APPENDIX H – Stage 1 Community Workshop Record of Comments

Redevelopment of the
Scottish Hospital Site

Design Evaluation Workshop

3 June, 2010

STEPHEN STREET ELEVATION

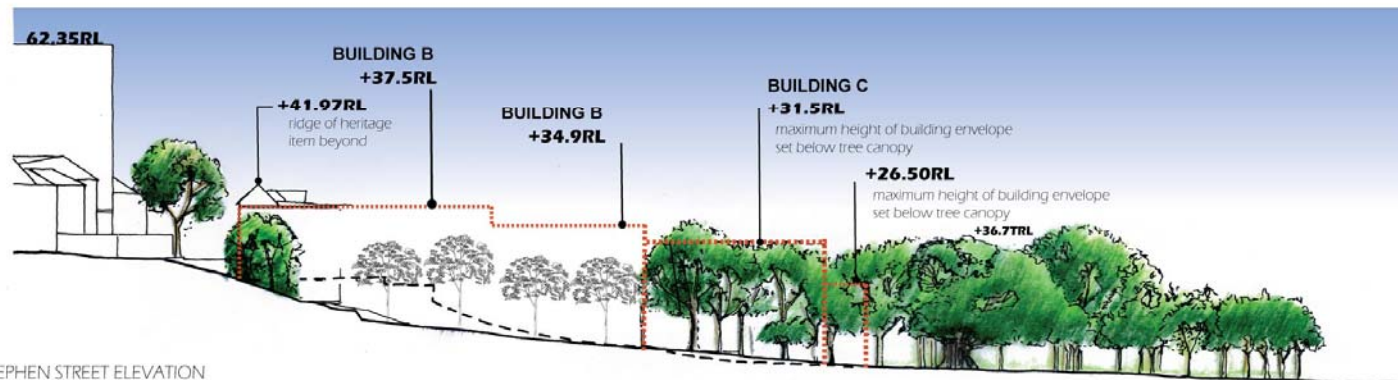
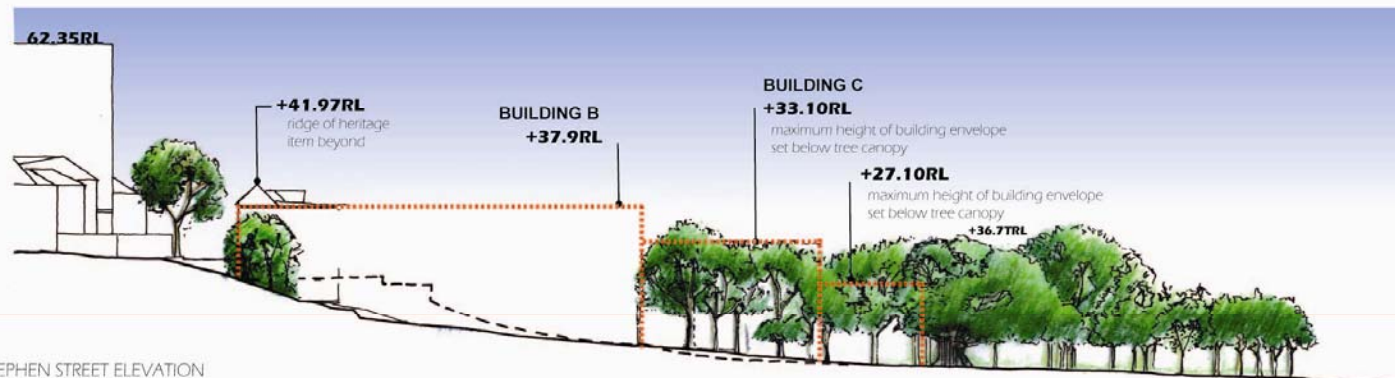
2. The built elevations for Stephen Street look different between GMU's master plan and JPR's design. Building C overcuts into the junction of Glen Street junction. Does Building C cut across Glen Street or not? The shaded area is this area 3 storeys, or is it higher? Can you explain how the Stephen Street elevation cascades?	<p>The site analysis prepared by GMU is shown as a "bubble diagram" and design principles. It does not represent a final architectural design solution.</p> <p>The northern face of building C when projected towards the eastern boundary currently coincides with the centreline of Glen Street where it terminates at Stephen Street.</p> <p>The shaded area is three storeys in height.</p> <p>The Stephen Street elevation cascades down starting from the Nursing Home building which will have a roof RL of approximately RL 37, to the smaller building for Independent Living Units that will have a roof RL of approximately 33.0. This ILU building will step down towards the north (Dillon Reserve) from five storeys to three storeys. The stepping is achieved by reducing the number of apartments per floor at the upper levels.</p>

7. There is little or no setback opposite No. 40 Stephen Street. 16 apartments face this canopy. 2	We note the concerns regarding the removal of vegetation at the Stephen Street frontage. We are

<p>10. The scale of buildings in Option 2 on Stephen Street are a concern. I am concerned about 29 metre depth and the area of land set aside for landscaping is not wide enough to support mature trees.</p> <p>(It was indicated that on the walk this depth was stated to be 18 metres in accordance with SEPP 65. There was confusion at the walk about the depth that was being referred to).</p>	<p>Apartment buildings under SEPP 65 and the Residential Flat Code are limited in depth to 18m. The urban design principles diagram indicates a built form along Stephen Street that would be 18m in depth. The principles diagram does not indicate a 'leg' of development along the park edge but the architectural interpretation does show a leg to test community reaction to built form along the park as well as Stephen Street.</p> <p>The Stephen Street setback will be reviewed as discussed in the consultation process. The opportunity for the proposed building to step back in elevation to provide substantial landscape area along the edge of Stephen Street is being investigated as are opportunities for widening Stephen Street itself north of Glen Street.</p>

<p>11. 10 metre width of Stephen Street is very narrow – this development is too close to the road carriageway and the residential development on the eastern side of the street.</p>	<p>Paddington is characterised by narrow streets with narrow footpaths and a continuous street wall of various building typologies. Stephen Street is a narrow street at its southern end particularly however the existing apartment building already creates a different scale for this end of the street and the proximity of the existing hospital building and the apartment block create an intimate relationship. The principles are based on trying to maintain taller, longer forms where they have traditionally existed on the site to minimise any impacts of those which already exist.</p> <p>The architectural interpretation of the principles results in the sort of massing characterised by the hospital building extending further to the north than the existing building and the team understands that there is some concern about this greater length as it changes the outlook from some apartments from trees to building form.</p> <p>The team will investigate whether a greater setback can be achieved whilst balancing this issue against other issues on the site.</p>

COMMENT/QUESTION	CONSULTANT RESPONSE
<p>12. The more land you give away the more you have to go up in height. Is that because you think it is easier to get through Council.</p> <p>People have never had this space before, so why now?</p>	<p>The urban design principles are based on best practice urban design approaches which seek to balance redevelopment with community improvements. The area of the site designated for the expansion of the reserve currently hosts major trees of heritage and community value. Providing this land to the community ensures these trees are kept in perpetuity and that a greater open space area is available for families and other residents to play and mingle. Given the density of Paddington it is very important to provide generous and well spaced public open space to balance the built form. There are very few opportunities in Paddington to increase open space and such an opportunity should not be wasted.</p> <p>The location of height and the maximum heights respond exactly to existing ridge heights and existing tree canopy levels on the site. They do not introduce greater heights but seek to locate taller forms within the tree copse so that it is hardly visible to the surrounding streets and does not impact on distant outlooks across the site. The team is undertaking more detailed studies of the heights relative to outlooks as part of developing the architectural response to ensure that the built form is 'tucked' into the trees.</p> <p>There is already a tall building on Stephen Street and it is adjacent to a much taller residential block. The scale and height of buildings increases from north to south and the topography of the site drops away relative to the street levels which rise. Therefore the location for built form and height is to the south within existing built form height generators. Neither the open space proposed or the heights have anything to do with ease of assessment by Council. They are a result of understanding the site issues and opportunities.</p> <p>The team believes that the expanded open space would be viewed by the majority of the community as an asset.</p>

42. The setback of the aged care building is too close to Stephen Street.	We have taken this on board and will review this design principle.
43. Building right to Stephen Street means that you are removing all of the trees.	The trees to Stephen Street to the south of Glen Street have been identified in the arborists report as being of low retention value. We will replace these trees but we acknowledge that new vegetation will take time to mature.
